WELWYN HATFIELD BOROUGH COUNCIL – DEVELOPMENT MANAGEMENT
DELEGATED REPORT

APPLICATION No:	S6/2013/916/FP
APPLICATION Site:	Oshwal Centre, Coppers Lane Road

The application seeks full planning permission for a two storey side extension which in-fills an existing recessed section on the east wall. At the lower ground level this will provide an extension to the lower hall and provide an improved access to an existing external patio area. At the upper level the new floorspace will provide storage space which will serve the main hall area.

DRAWING TITLE	
EXISTING AND PROPOSED PLANS	
DATE	27.03.2013
SCALE	1:200 @ A1
DRAWING NO.	6842/03/P0
REVISION	
DRAWN BY	SR
CHECKED BY	LV

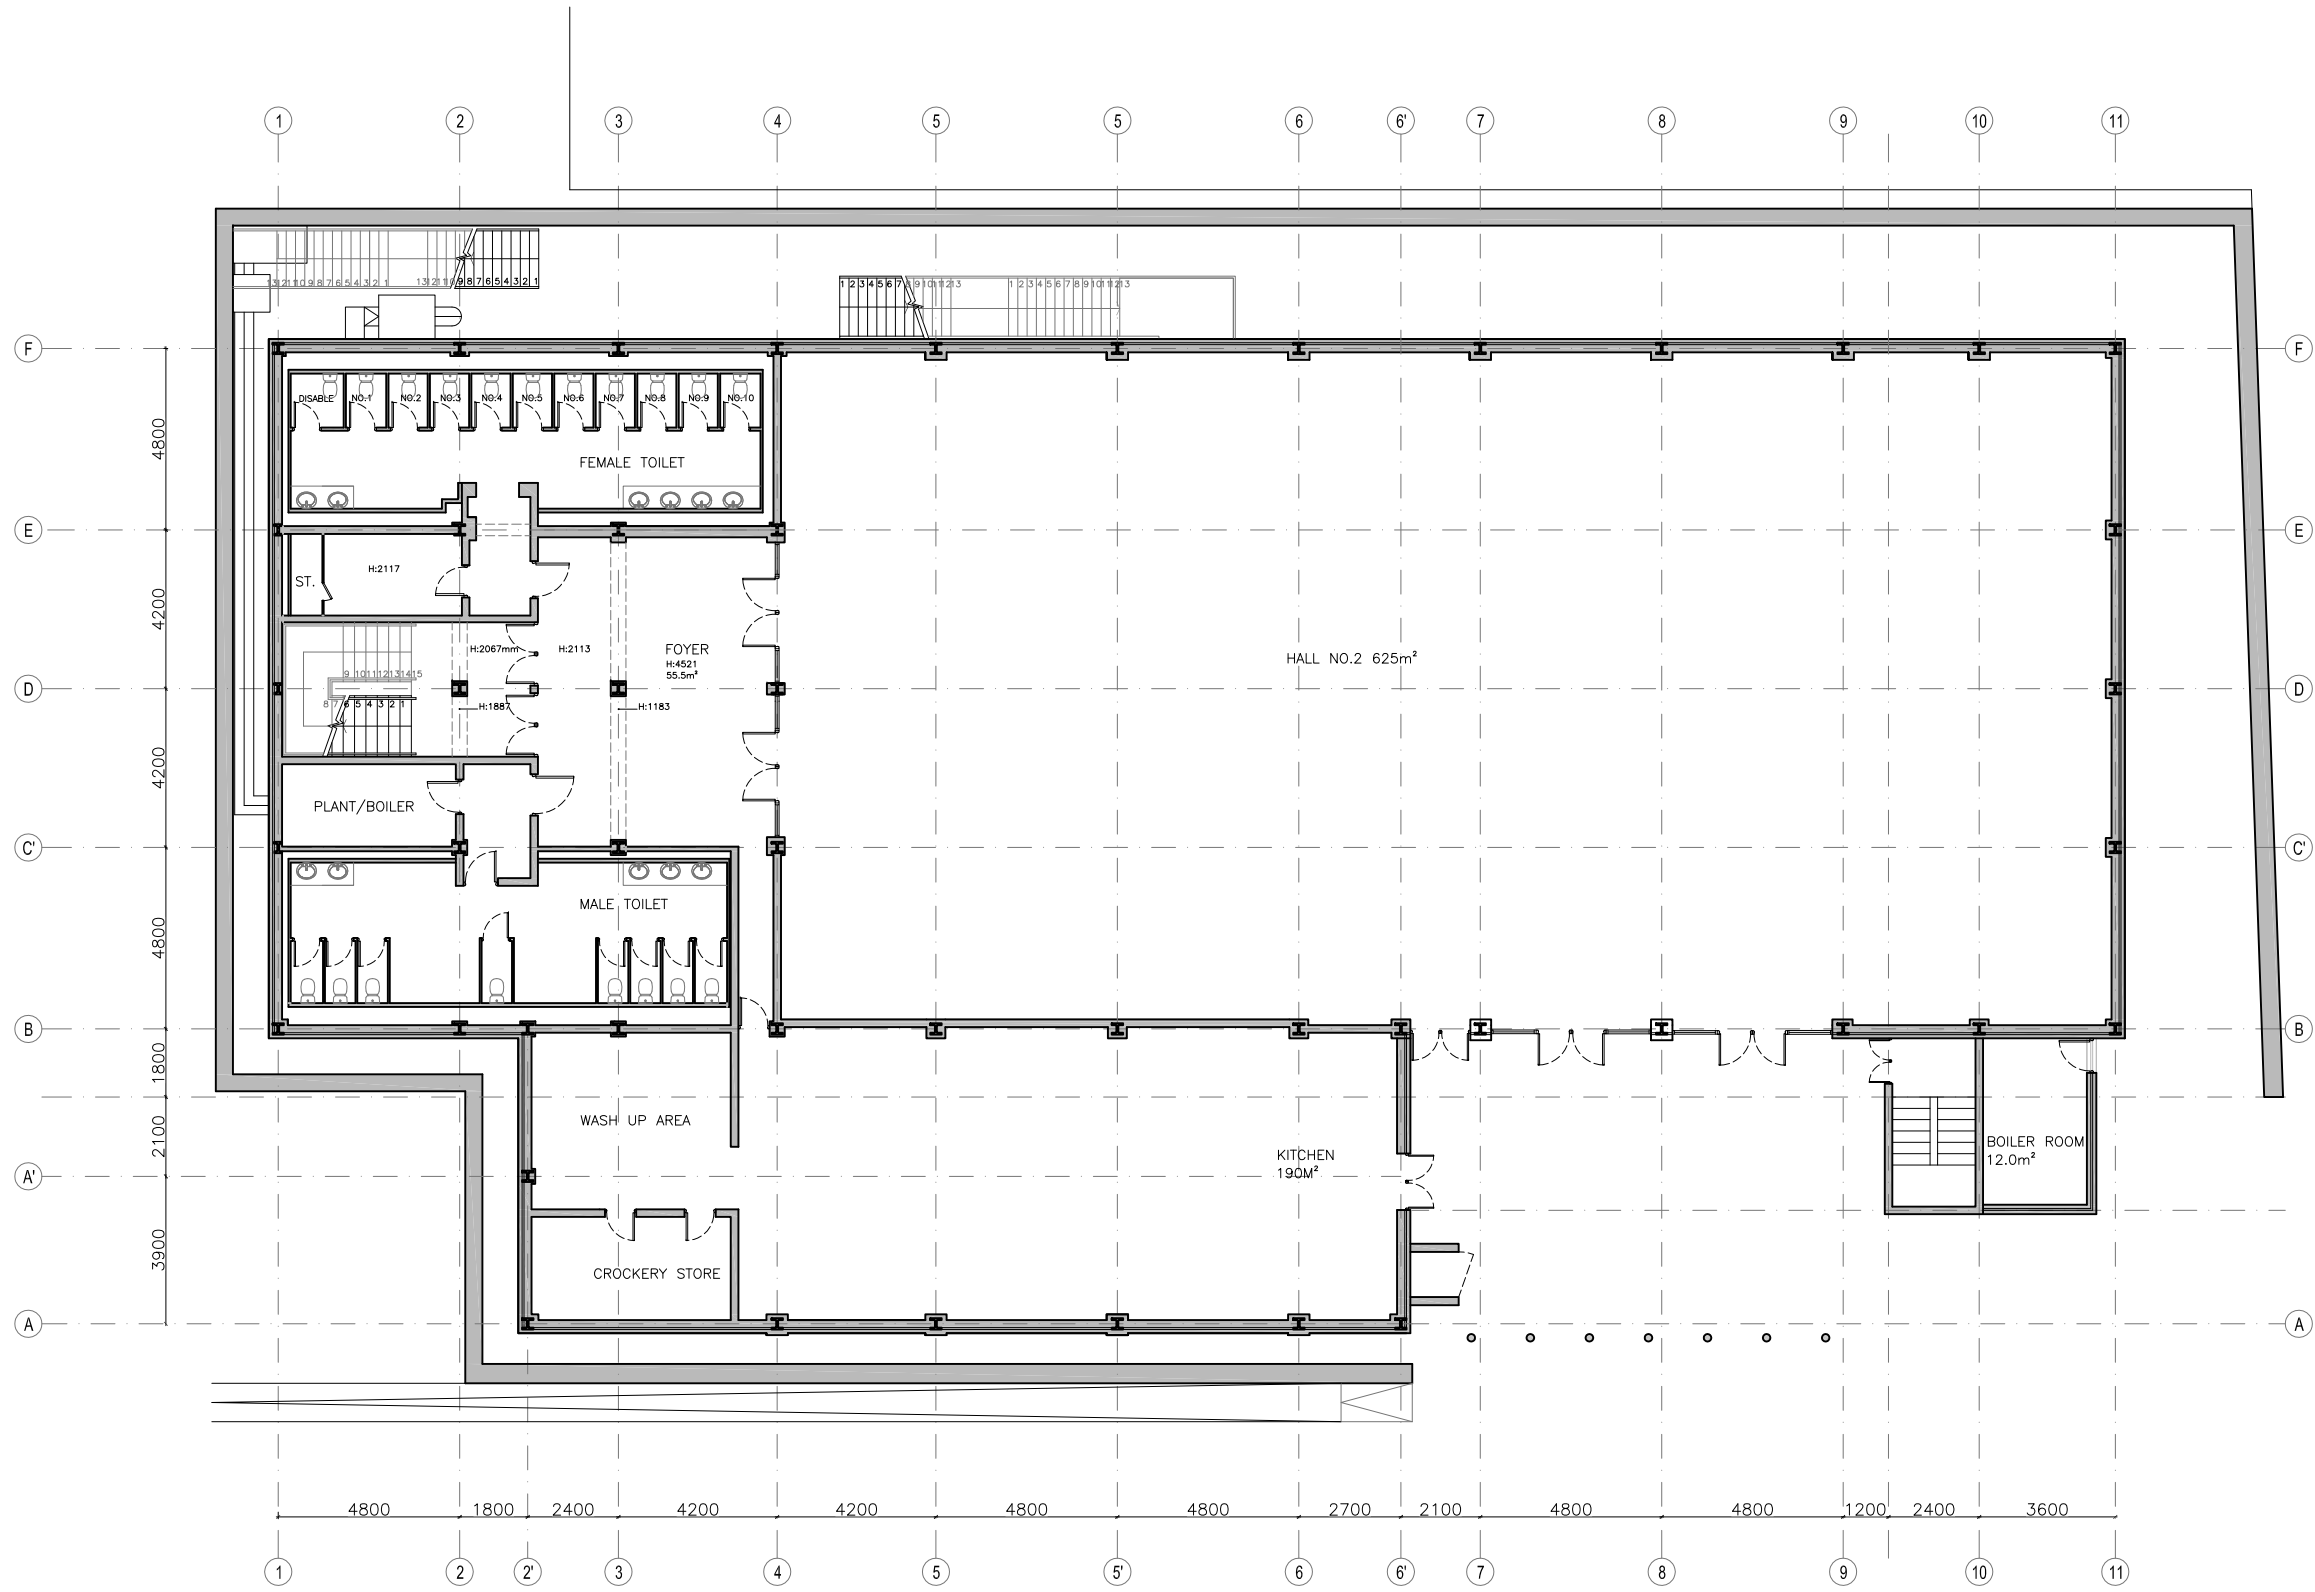
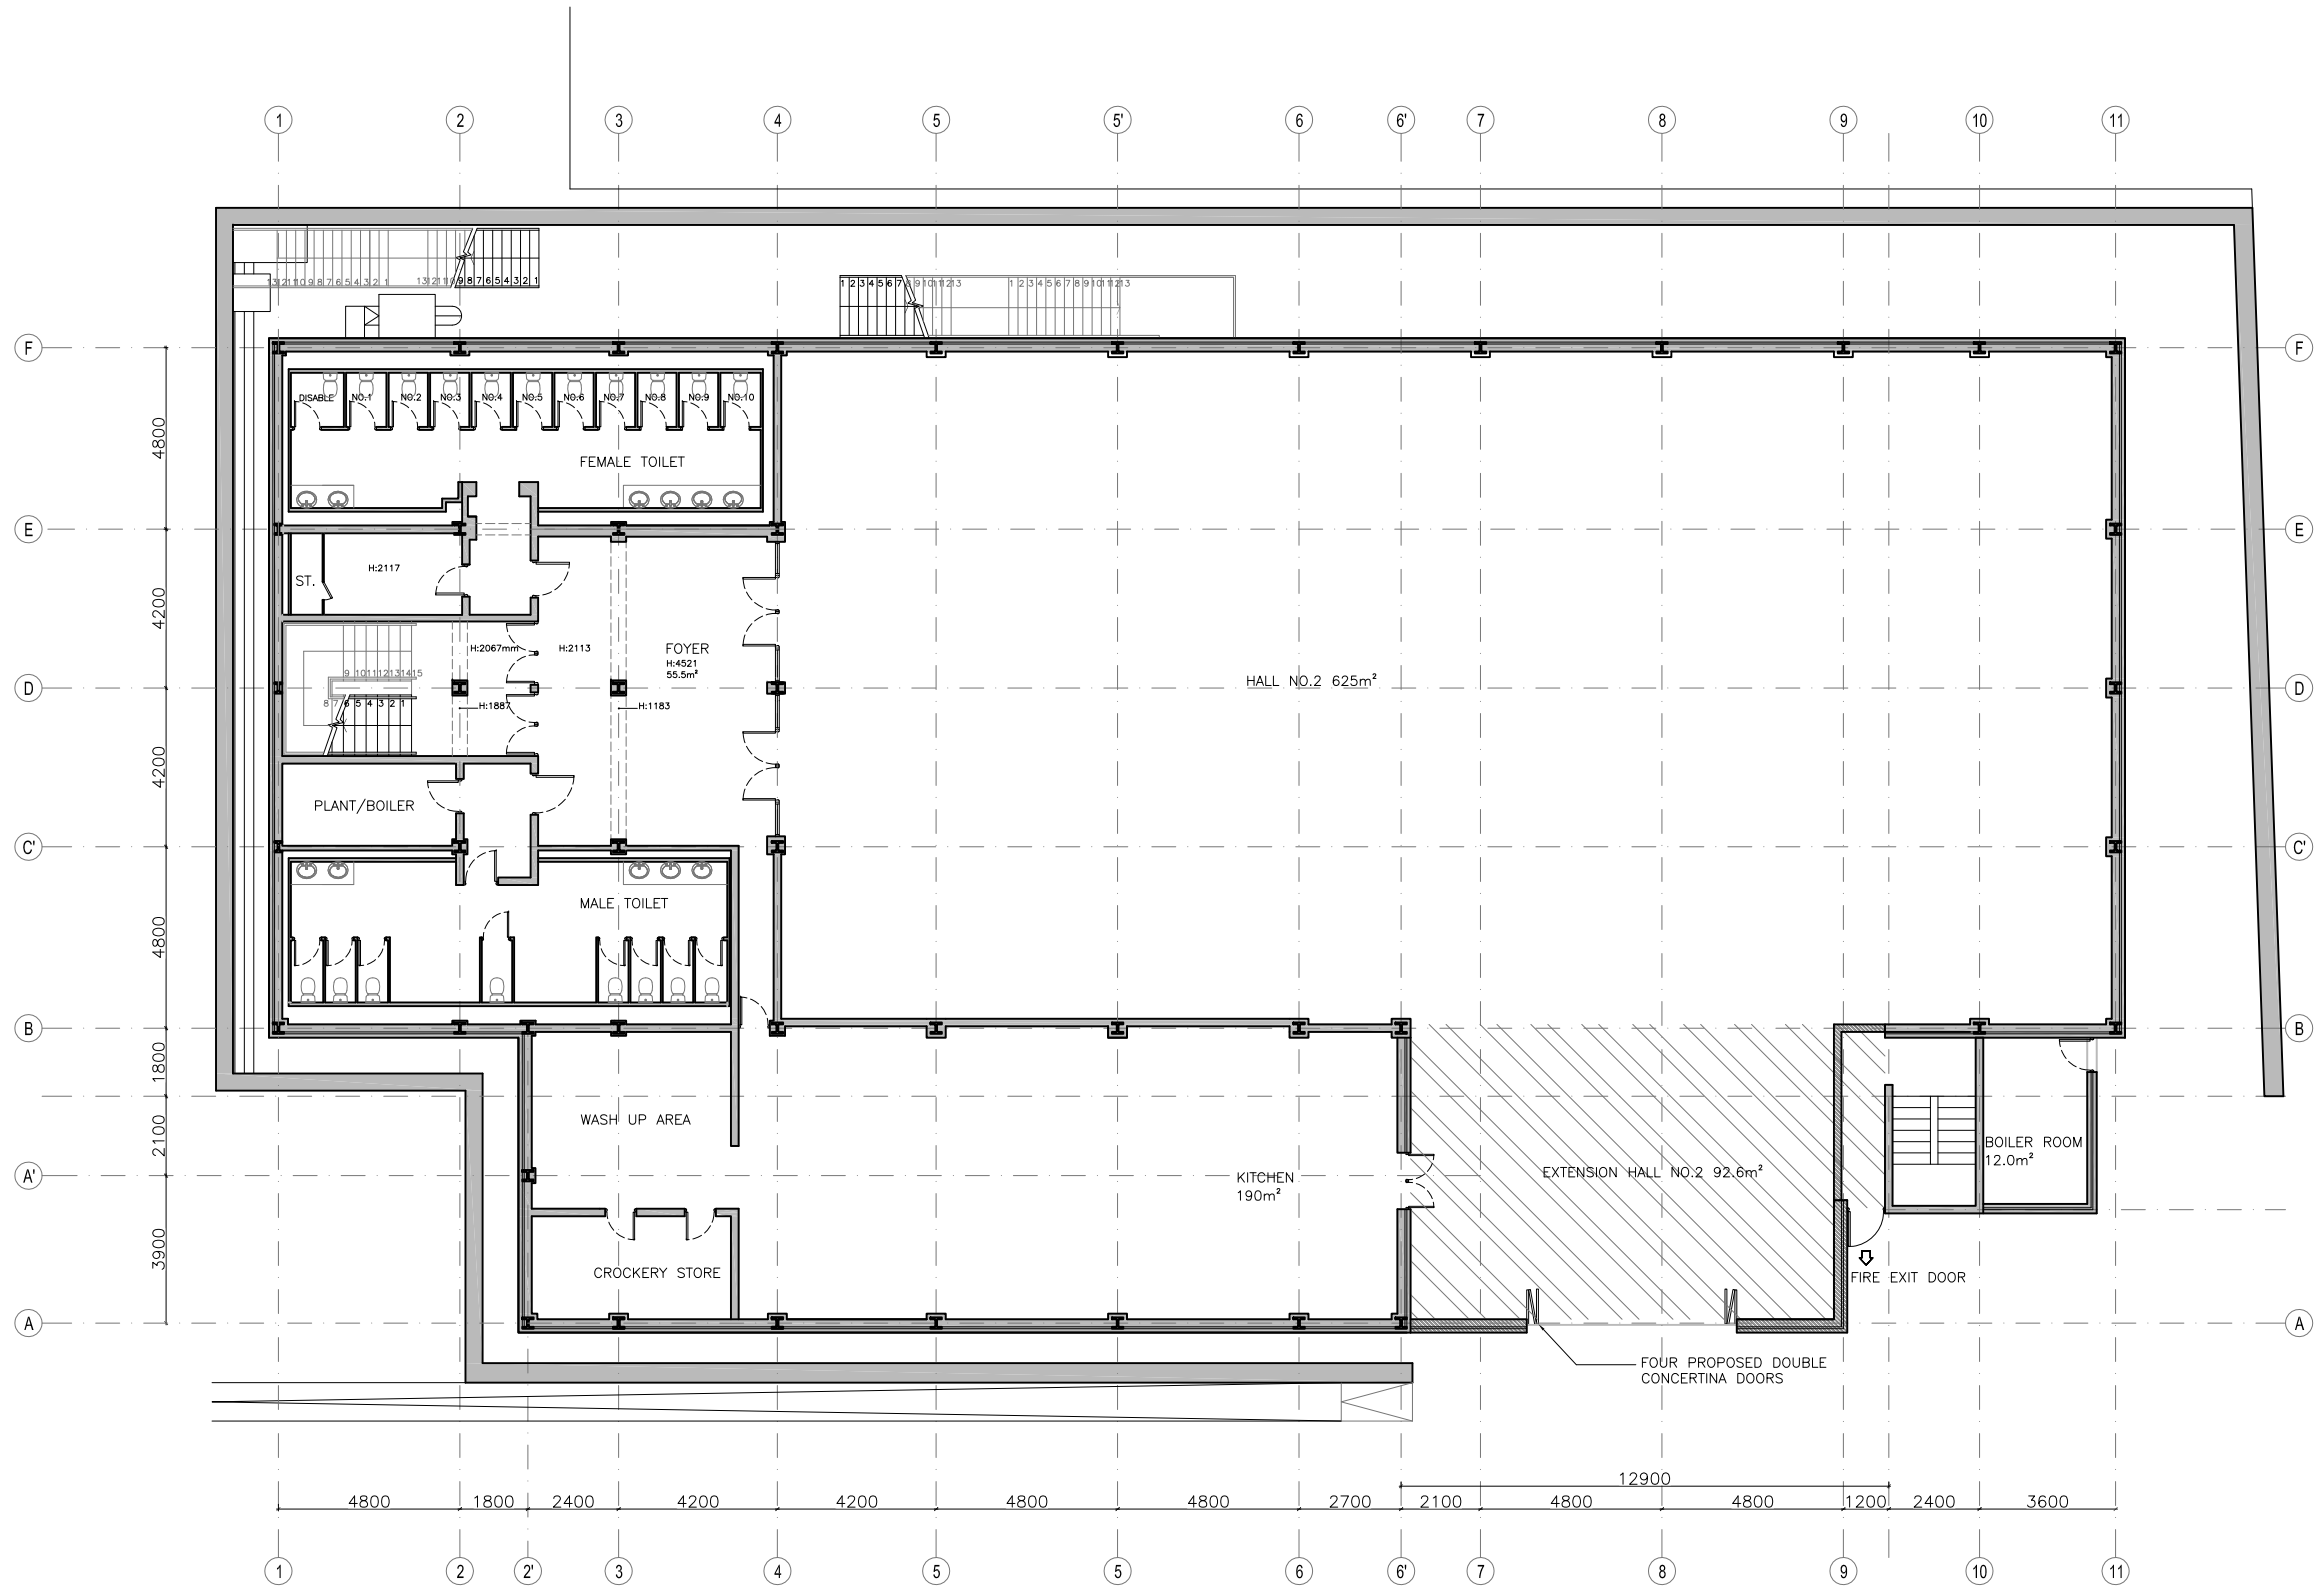
At ground floor level the existing double doors are to be replaced by a total of four double doors to provide better access to the patio for all users.

Disabled Access: Local Plan Policy D9 is relevant. The proposed development will improve access on the ground floor by creating new double doors. As such the proposal is considered to comply with Local Plan Policy D9.
